Date 7<sup>th</sup> October 2024

### **RE: Land at Toddington Lane Littlehampton BN17 7PN**

Thank you for your correspondence of the 7<sup>th</sup> of October 2024, advising me of a planning application for the demolition of existing structures and development of land to create 10 No. residential dwellings, landscaping, access, car parking and cycle parking at the above location, for which you seek advice from a crime prevention viewpoint.

Sussex Police response

Proposed layout

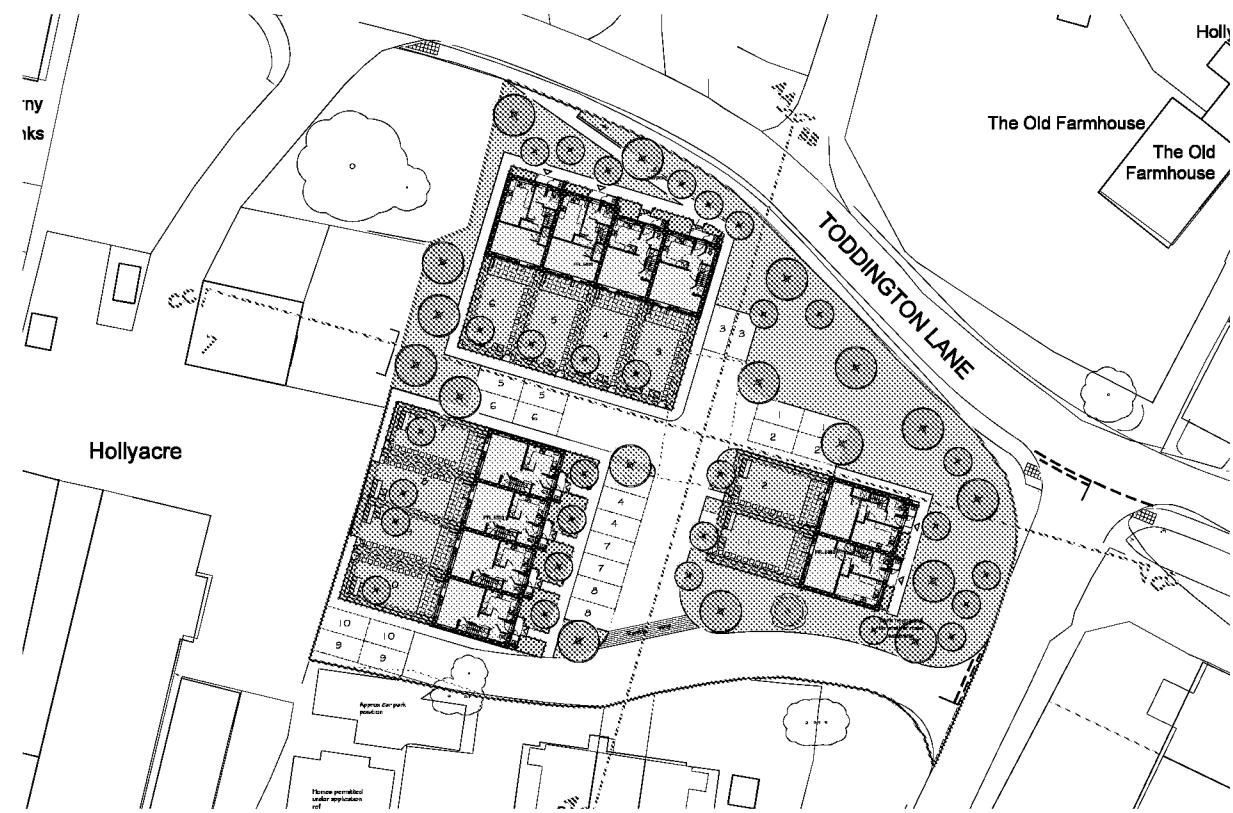
A good active frontage has been created with the streets and the public areas being overlooked.

Where parking occurs within the development it should be designed to ensure good natural surveillance and ideally be within view of an active room. An active room is where there is direct and visual connection between the room and the street or the car parking area. Such visual connections can be expected from rooms such as kitchens and living rooms, but not from bedrooms and bathrooms.

With regards to cycle storage throughout the development - research by the 'Design against Crime Centre' suggests that cyclists should be encouraged to lock both wheels and the crossbar to a stand rather than just the crossbar and therefore a design of cycle stand that enables this method of locking to be used is recommended. The minimum requirements for such equipment are as follows:

In order to maintain as much natural surveillance as possible – ground planting throughout the development should not be higher than 1 metre with tree canopies no lower than 2 metres. This arrangement provides a window of observation throughout the area. This will enable capable guardians to report incidents to the authorities should they occur. A capable guardian has a 'human element' that is usually a person who, by their mere presence would deter potential offenders from perpetrating a crime.
